Recommendation Report for Planning Permission for Works or Extension to a Dwelling

REF NO: AW/360/14/HH

LOCATION: 91 The Fairway
Aldwick

PROPOSAL: Side extension for garage & store with guest suite over. This application affects the character & appearance of the Aldwick Bay Conservation Area.

SITE PLAN 1-500

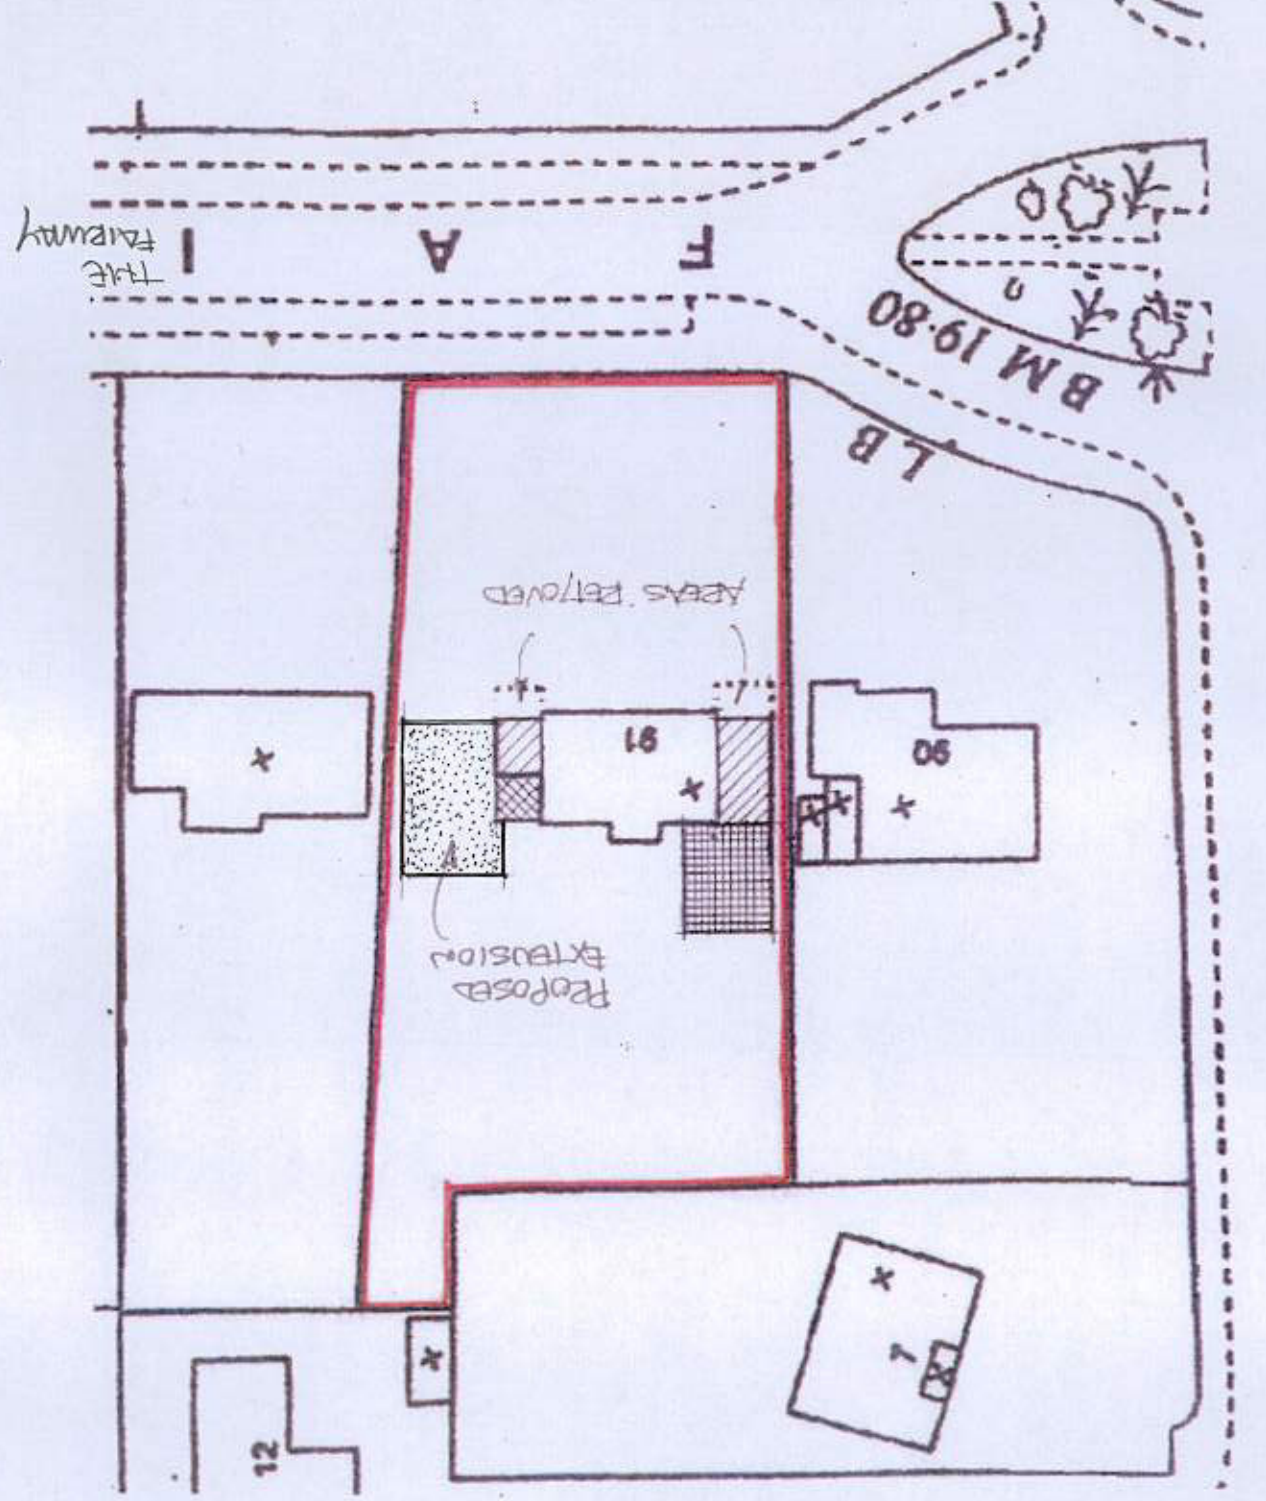
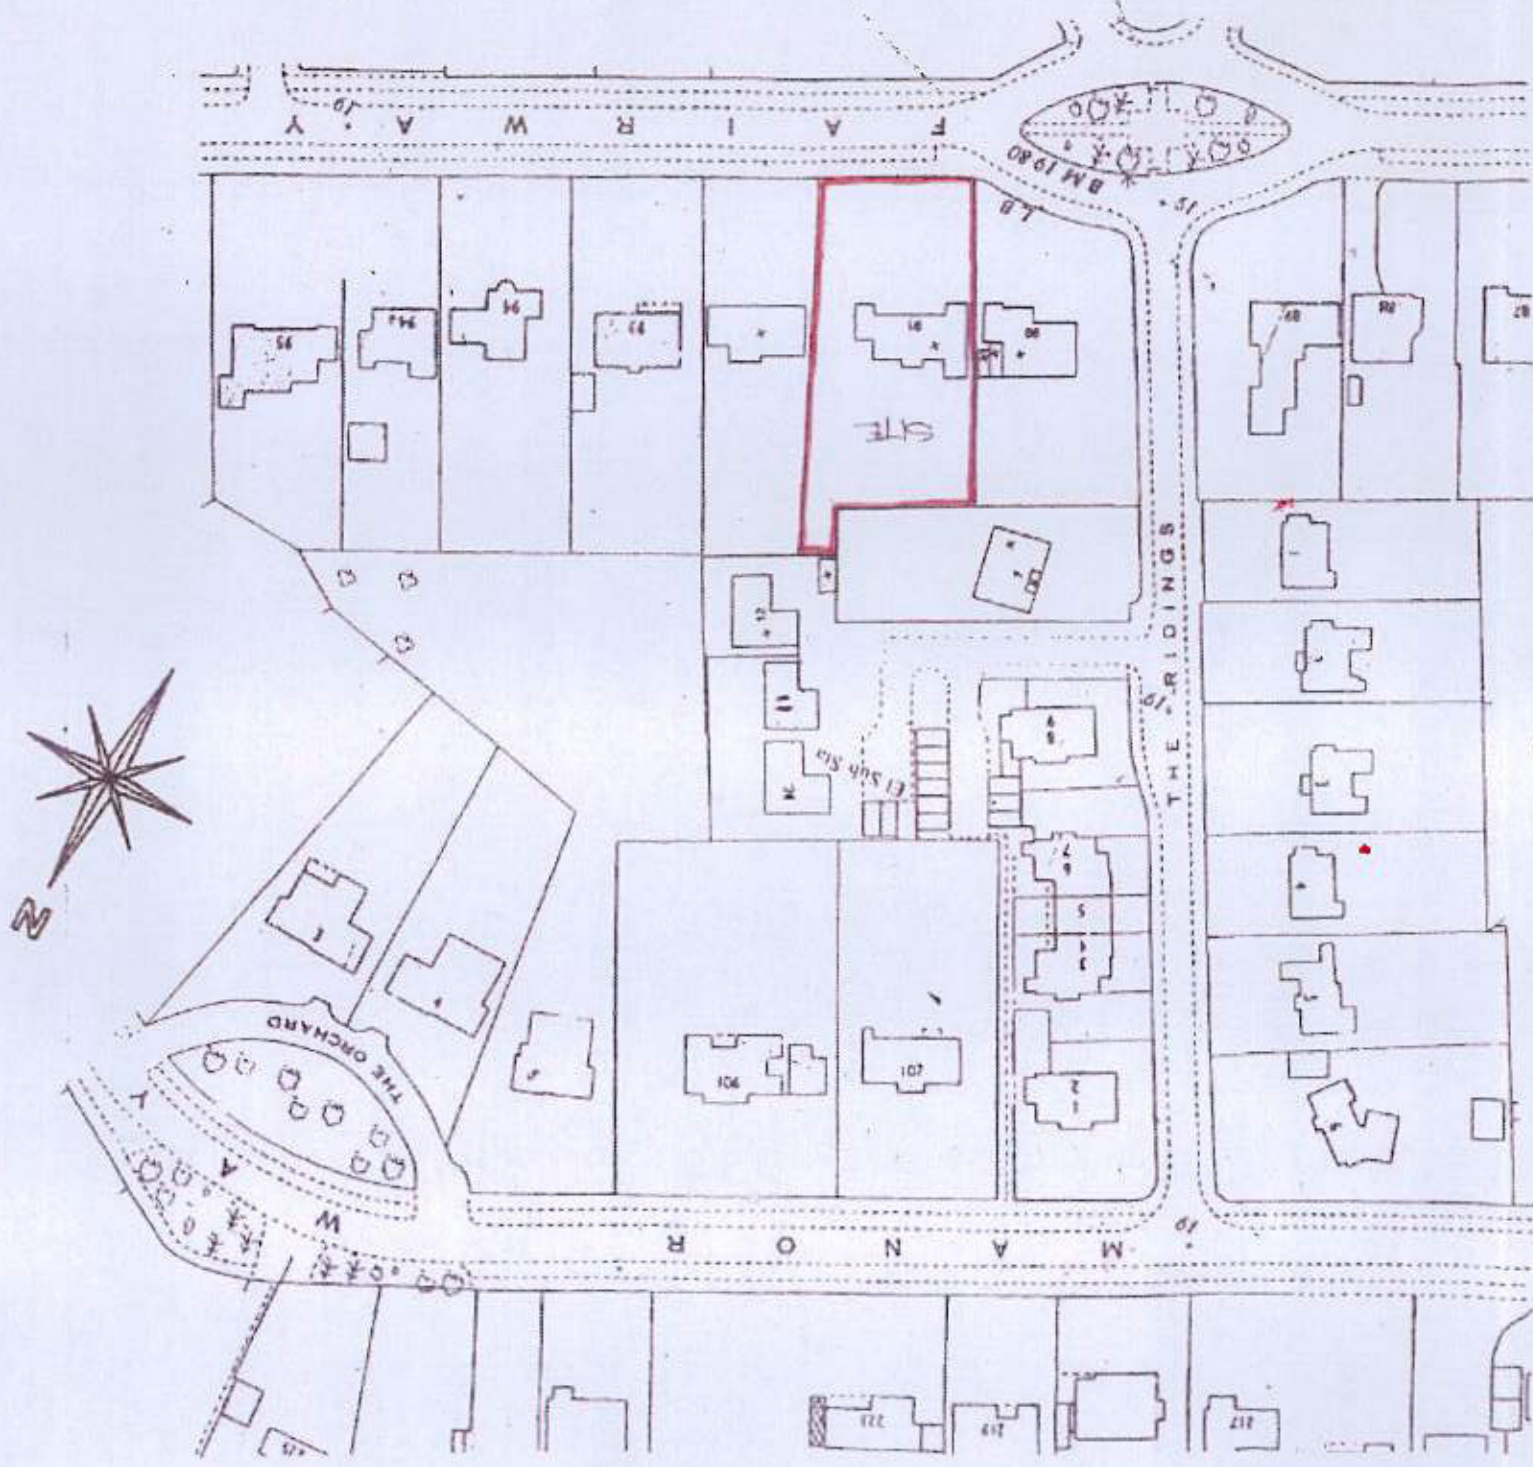
1. There is a tall hedge along the east boundary, made up of conifers/shrubs/trees which is not shown on the site plan. This will be affected by the proposed extensions. The drawings should show the position and width of the hedge and varieties and to what extent it is going to be removed/retained/replaced.

These comments resulted in a revised drawing being submitted which shows removal of the existing hedge and planting of a privet hedge.

SIDE ELEVATION (EAST) PROPOSED 1:100.

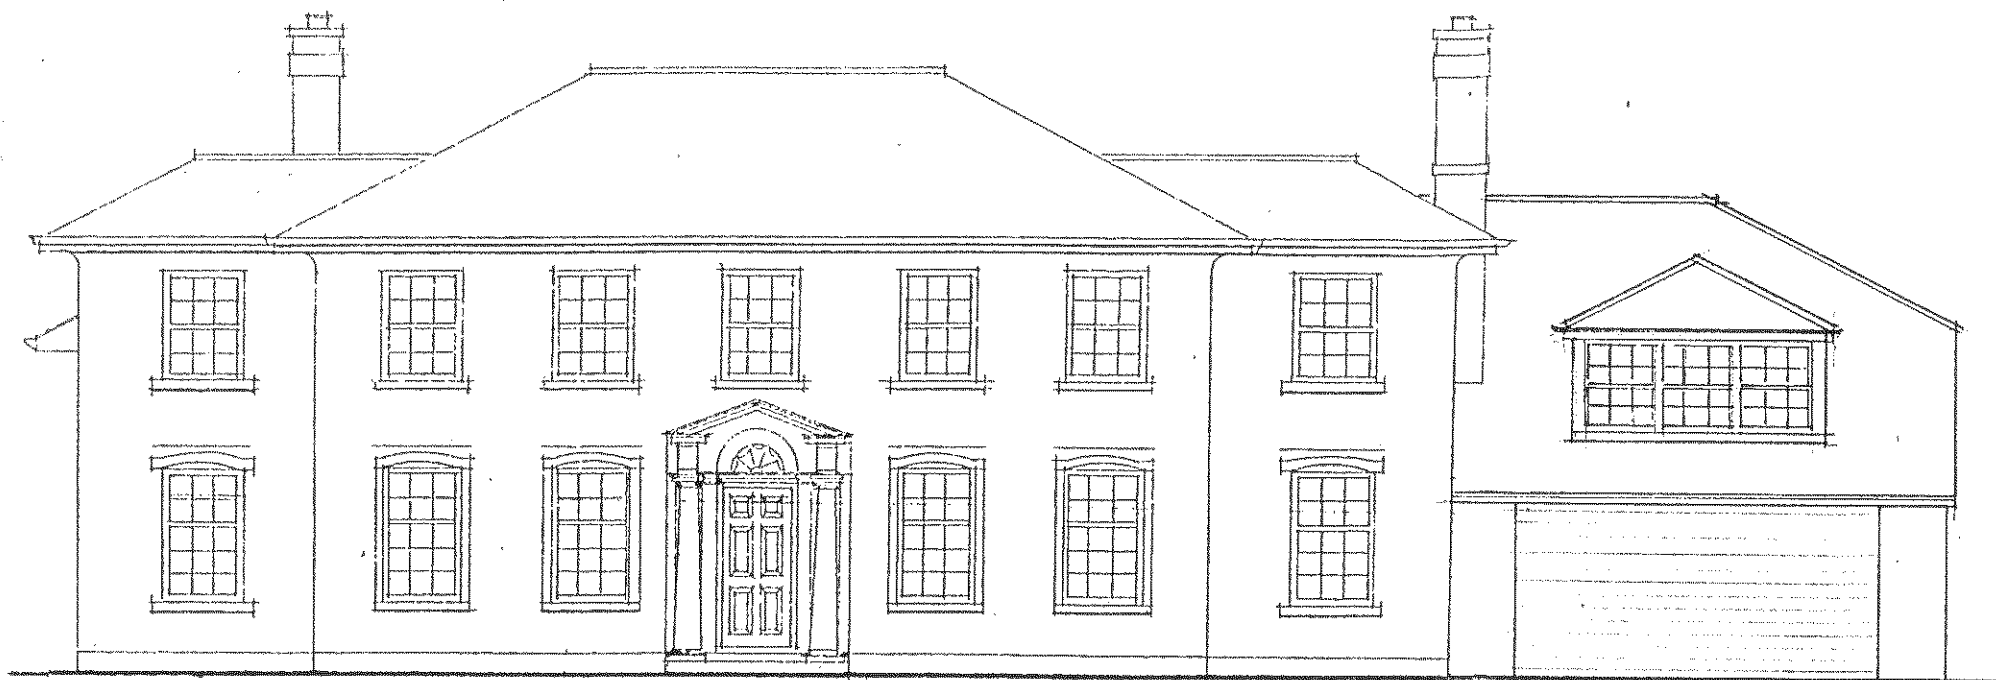
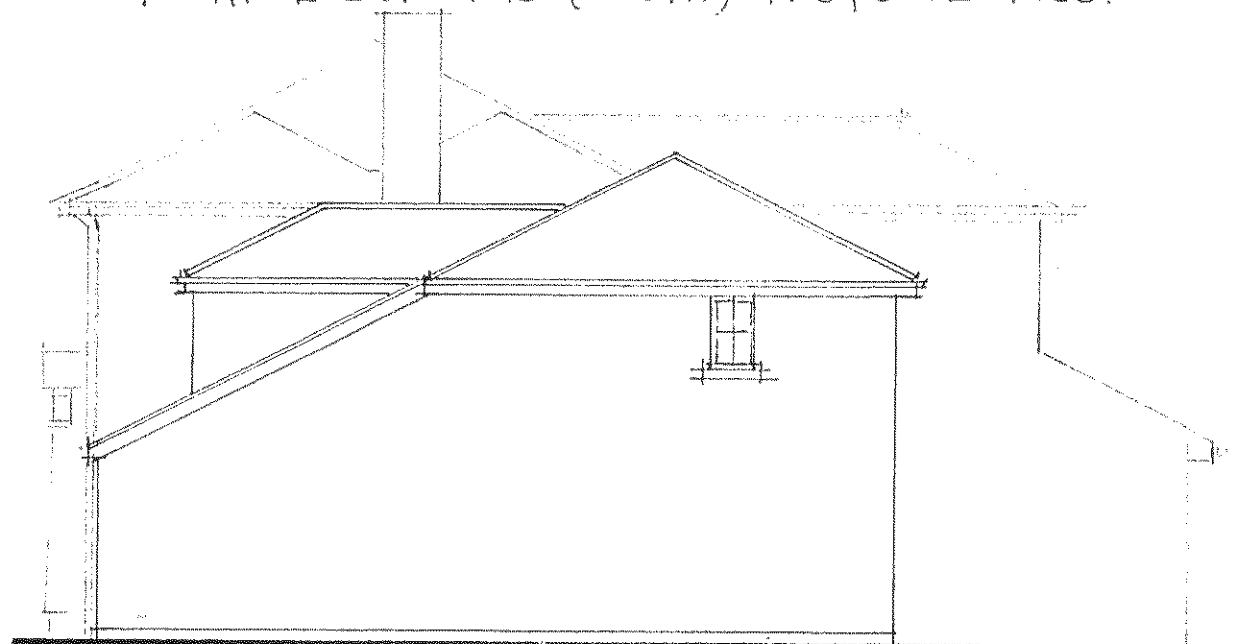
3. The new bathroom window to the east should be frosted glass and fixed below 1.7m above floor level.

The proposed extension seeks to utilise this remaining space to the east by erecting the proposed extension, the appearance of which has already been described earlier. Whilst the extension would have a lower ridge line and slightly set in front wall, it is still substantial. The design of the extension clearly seeks to mitigate potential visual impact. However, the result is that the proposed extension has a somewhat incongruous appearance when viewed alongside the symmetry of the existing dwelling. In addition, it does not reflect the design and appearance of the existing dwelling. In these senses, it is considered to be detrimental to the appearance of the existing dwelling.

The proposed extension includes a first floor side bathroom window. this is not consider to be something which would necessarily result in detriment were permission to be granted, as a condition requiring obscure glazing an a non-opening window could be imposed.

- 1 The proposal would result in the erection of an extension which would be detrimental to its appearance as a due to its incongruous visual appearance and its impact on the symmetrical appearance of the existing dwelling and would fail to preserve or enhance the character or appearance of the Conservation Area. The proposed development would therefore be contrary to policies AREA2, GEN7 and DEV19 of the Arun District Local plan 2003.

REAR ELEVATION (NORTH) 1:100

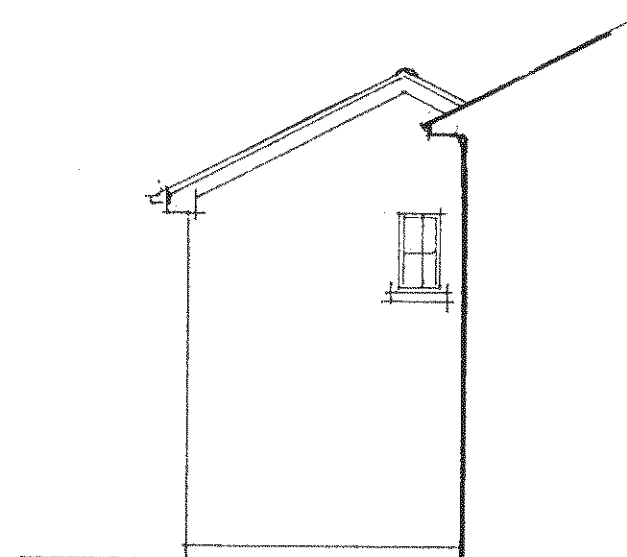
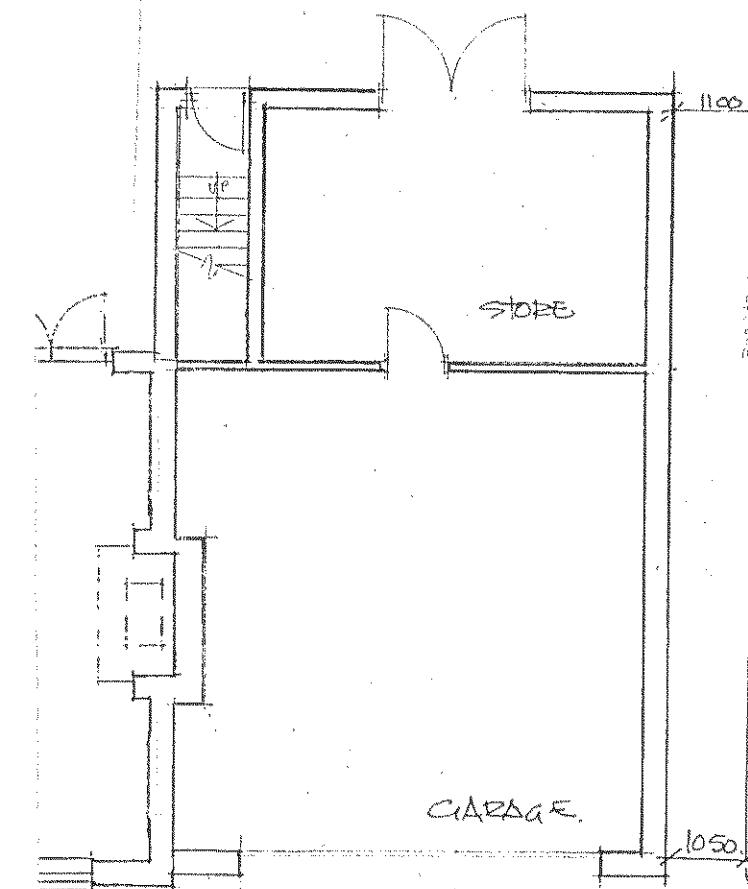
2. The rear of the extension is 2 storeys high and may affect the incoming light of the adjoining garden and house to the east, 92 The Fairway.

SIDE ELEVATION (EAST) PROPOSED H100.
EXTENSION

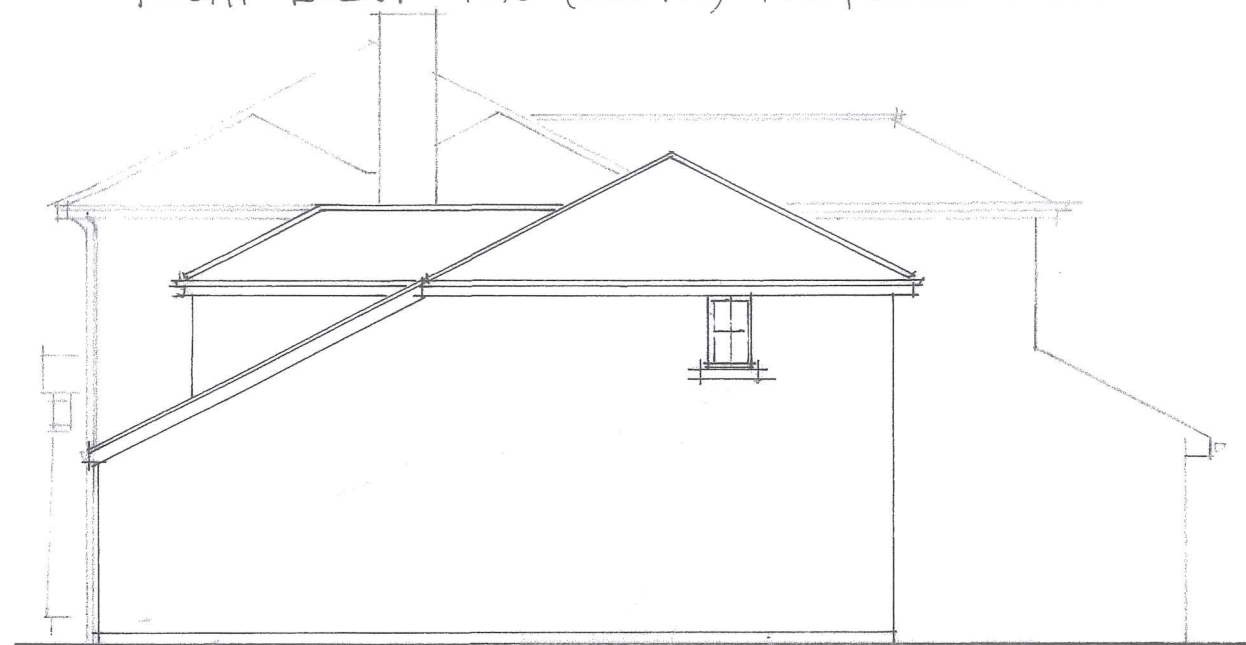
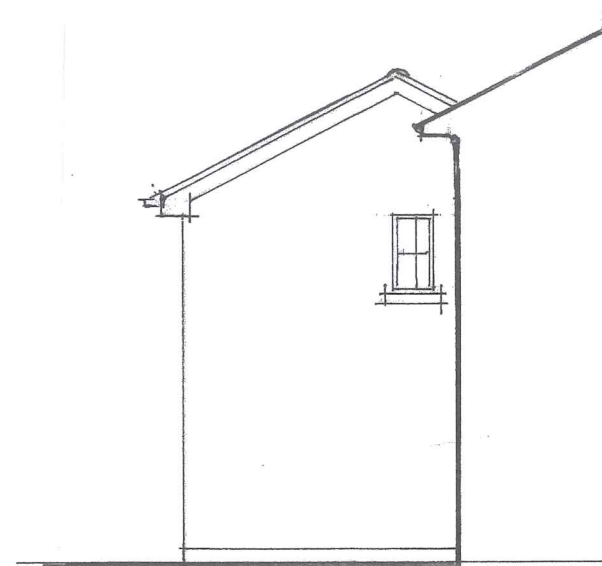
The adjoining dwelling is presently well screened, this screening would be lost if the proposed extension were permitted and built. This dwelling has a side flank wall facing the site and it is not considered that detriment to the amenity of the occupiers would result from the extension, although the loss of screening until such time as replacement screening established itself would impact.
